**Consultation Response from KC,  
Lead Local Flood Authority**

**2021/94280 land at, Lady Ann Road, Soothill, Batley, WF17 0PY**

**Erection of 67 dwellings with associated works**

**Date Responded: 21<sup>st</sup>  
December 2021**

PROPOSED SITE PLAN

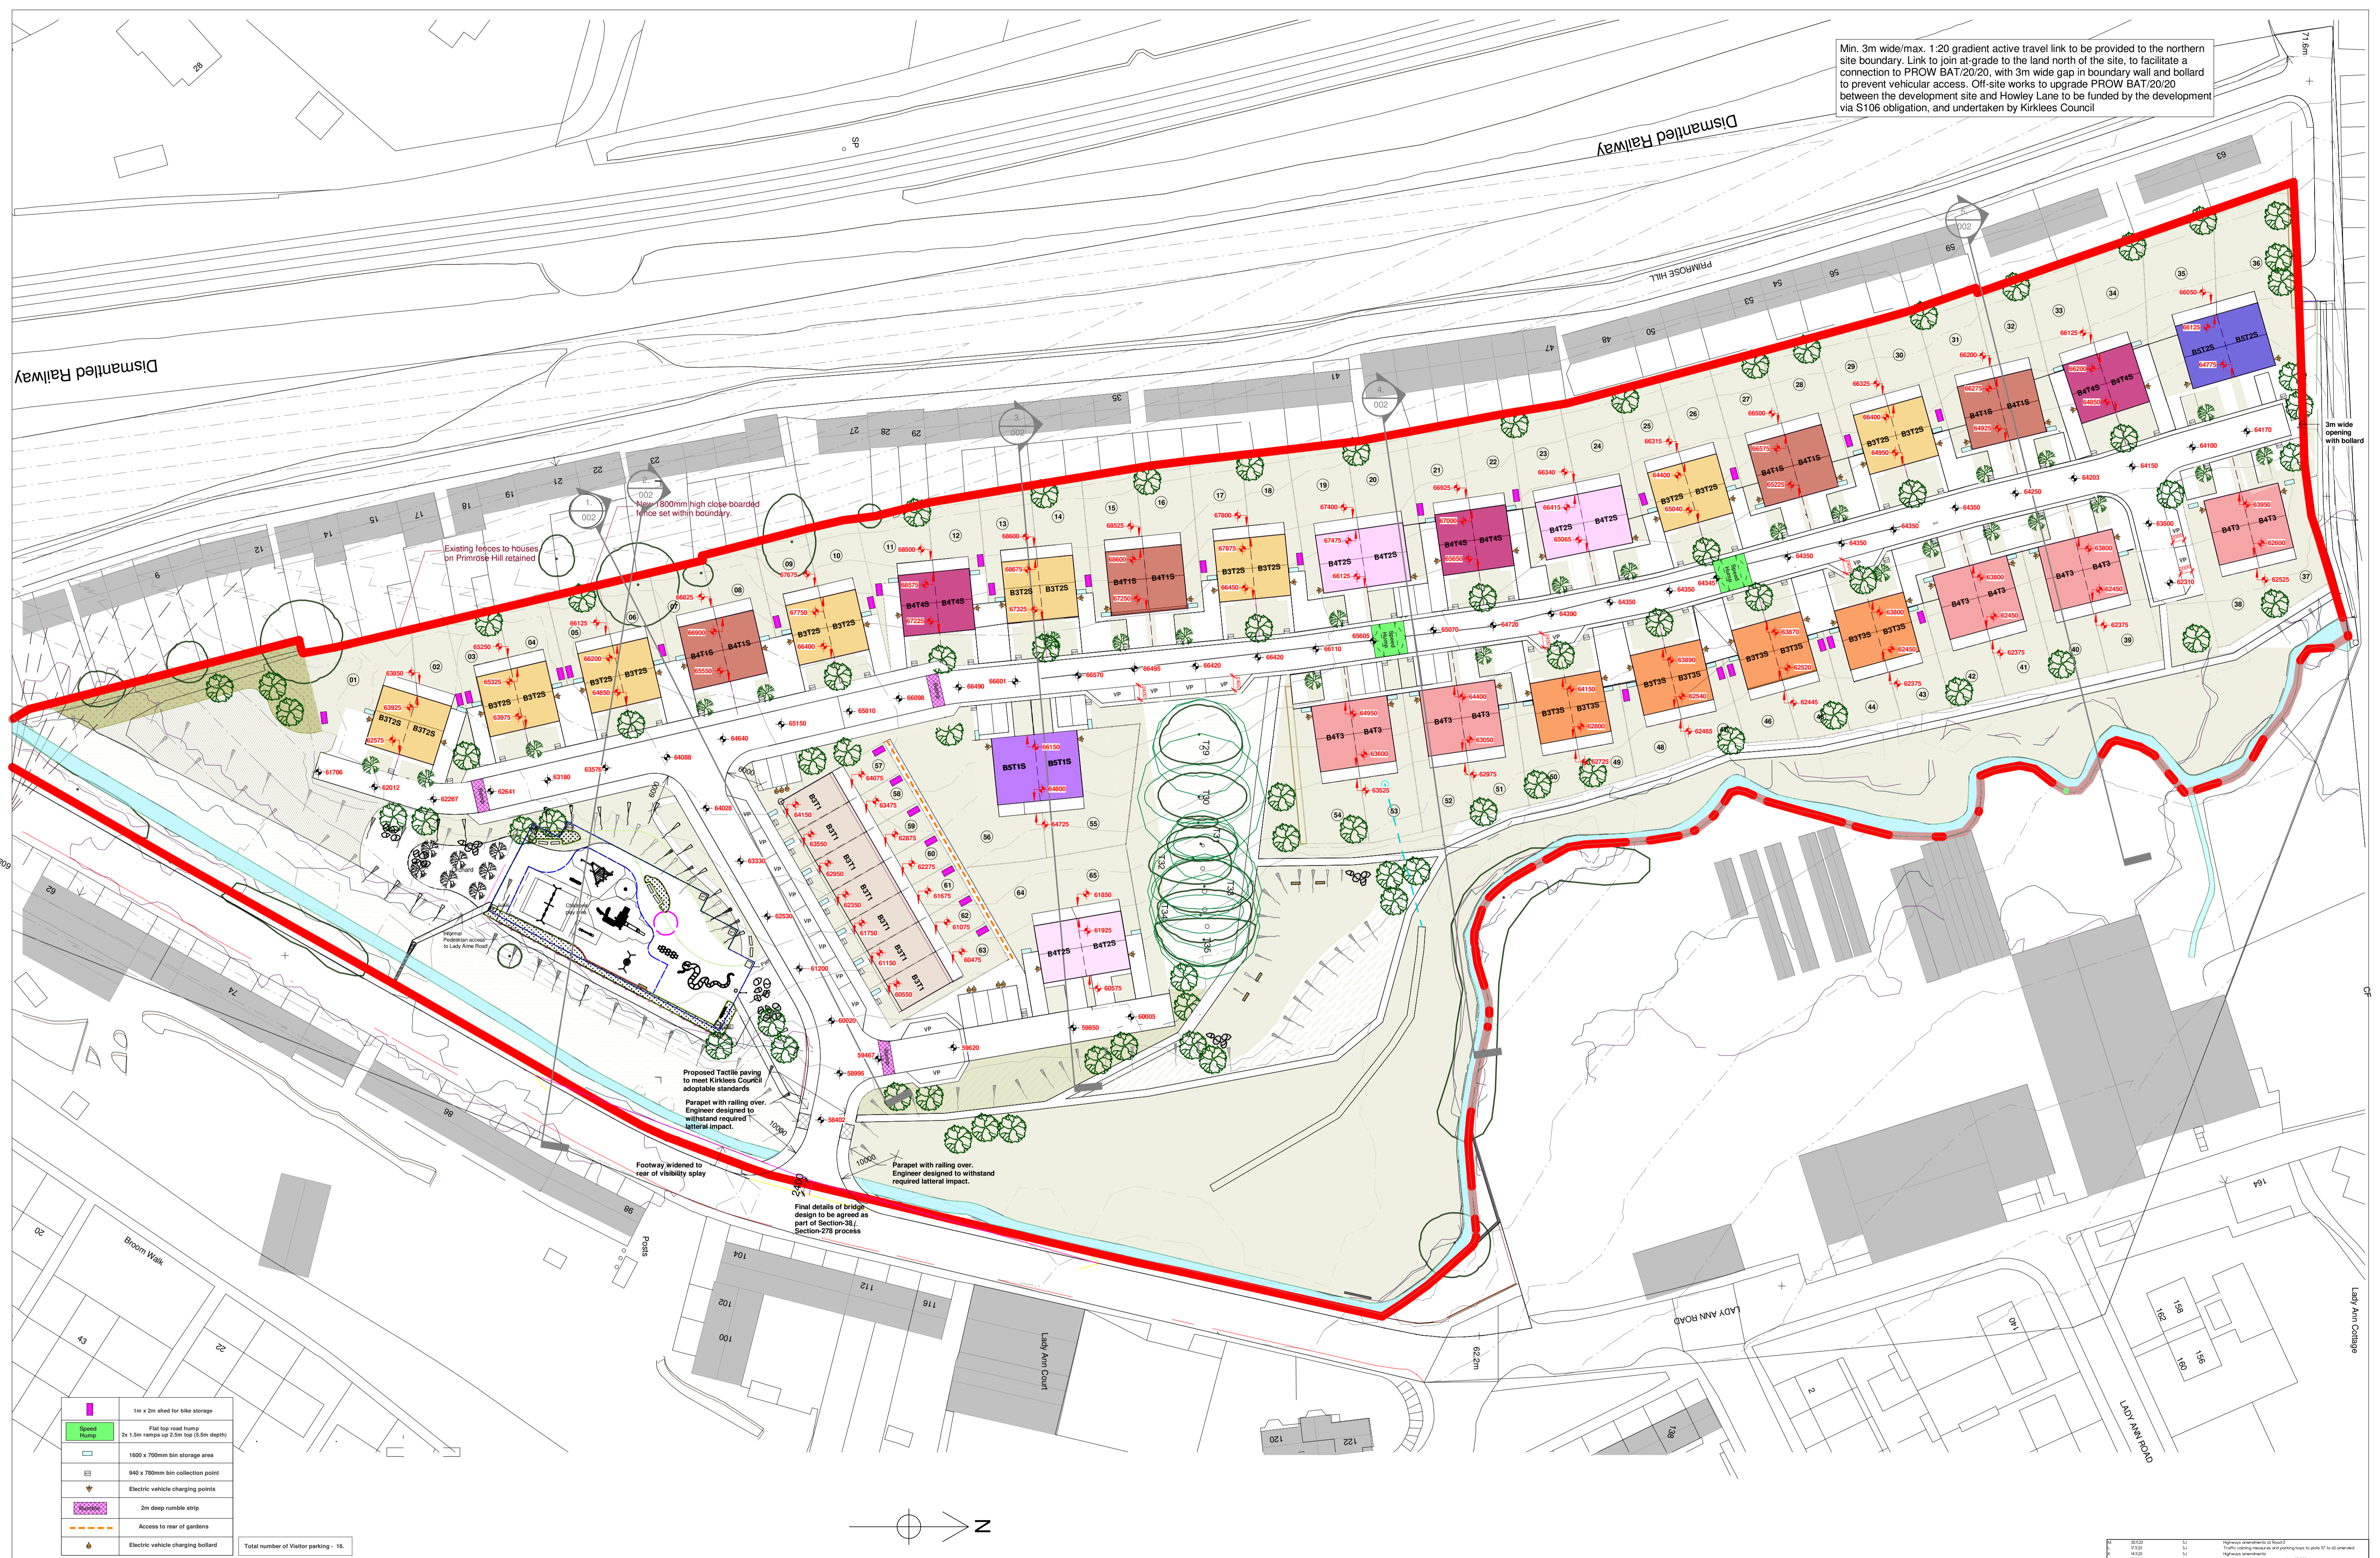
**Kirklees Flood Management & Drainage is awaiting FURTHER INFORMATION before making a detailed consultation response. The Applicant's drainage engineer has been informed.**

- Layout depicting picking up and safe routing to watercourse of the spring emerging in the middle of the site.
